Our Ref: BR/183/19/HH
Your Ref:

Town & Country Planning Act 1990 (as amended)
Town & Country Planning (Development Management Procedure) (England) Order 2015
Application for Planning Permission for Works or Extension to a Dwelling

Development Single storey rear extension & bedroom in roof, following demolition of existing kitchen extension & conservatory.
Location 37 Hillsboro Road Bognor Regis West Sussex

BLOCK PLAN
Scale 1:500

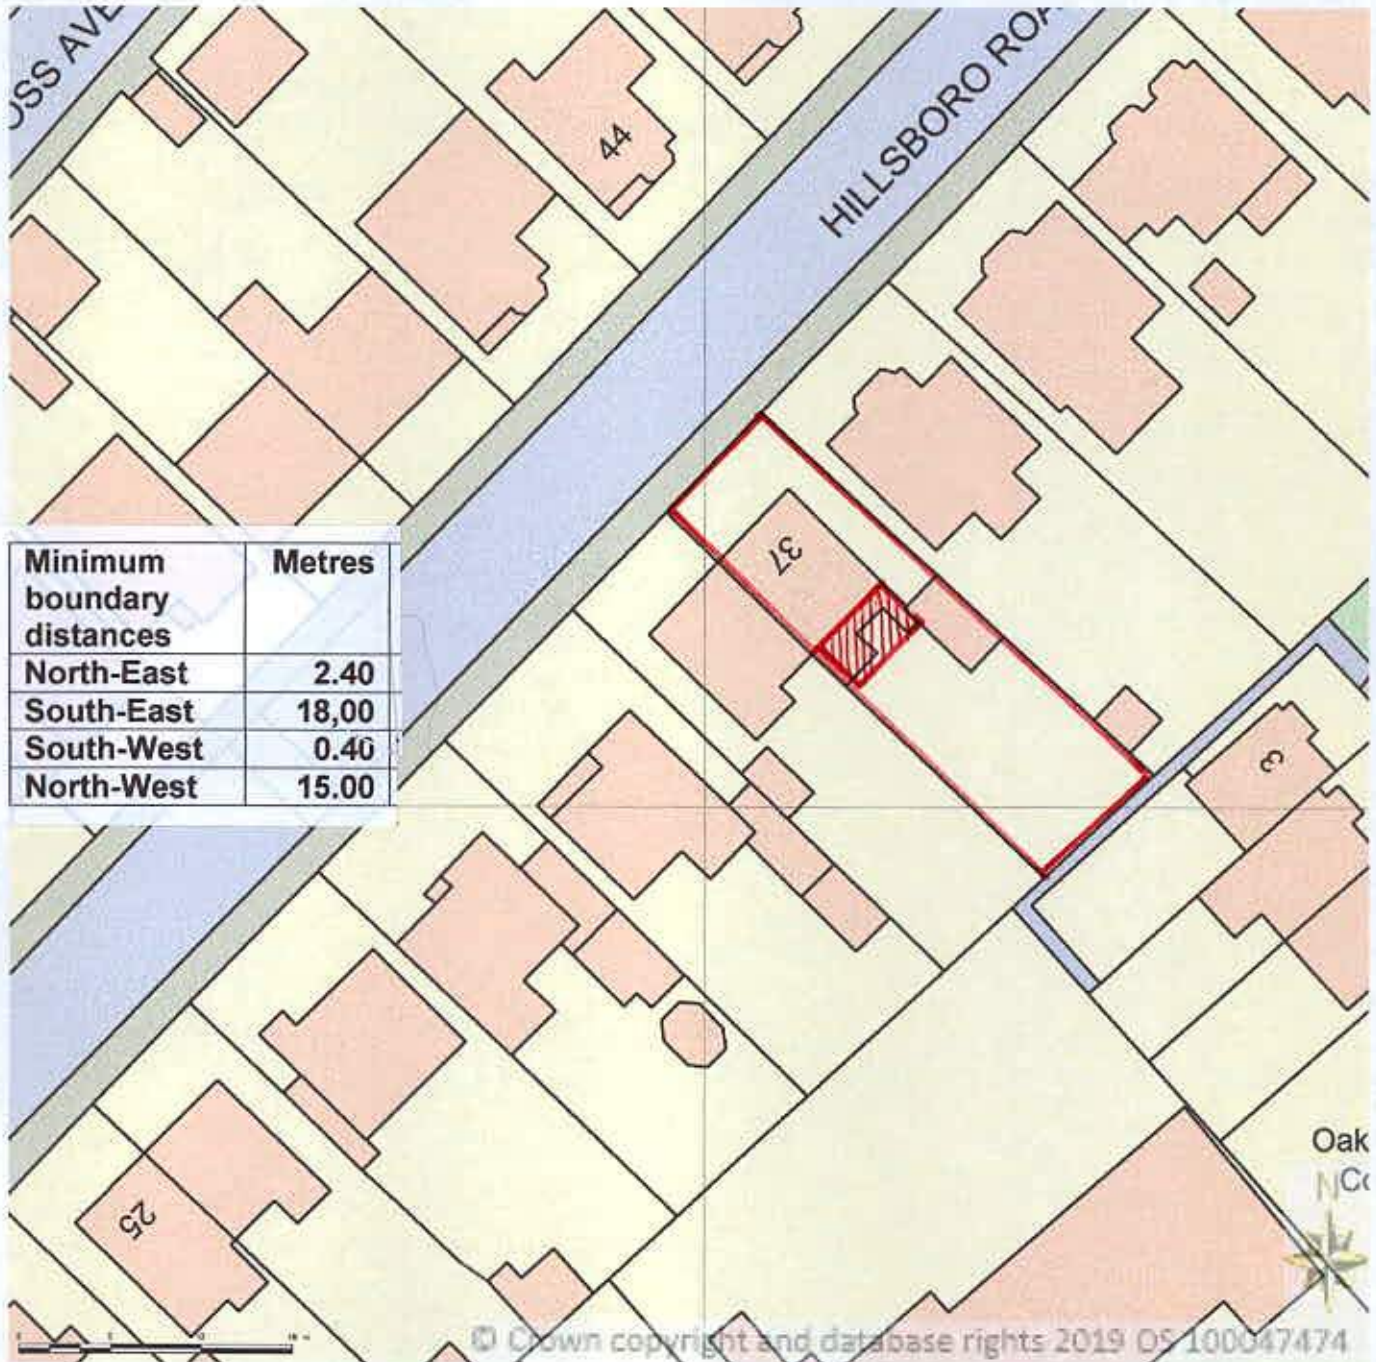
Block Plan

Please submit 1 electronic or 3 paper copies of an amended block/site plan at a scale of 1:500 or 1:200 showing the measurements from the proposal to the boundaries
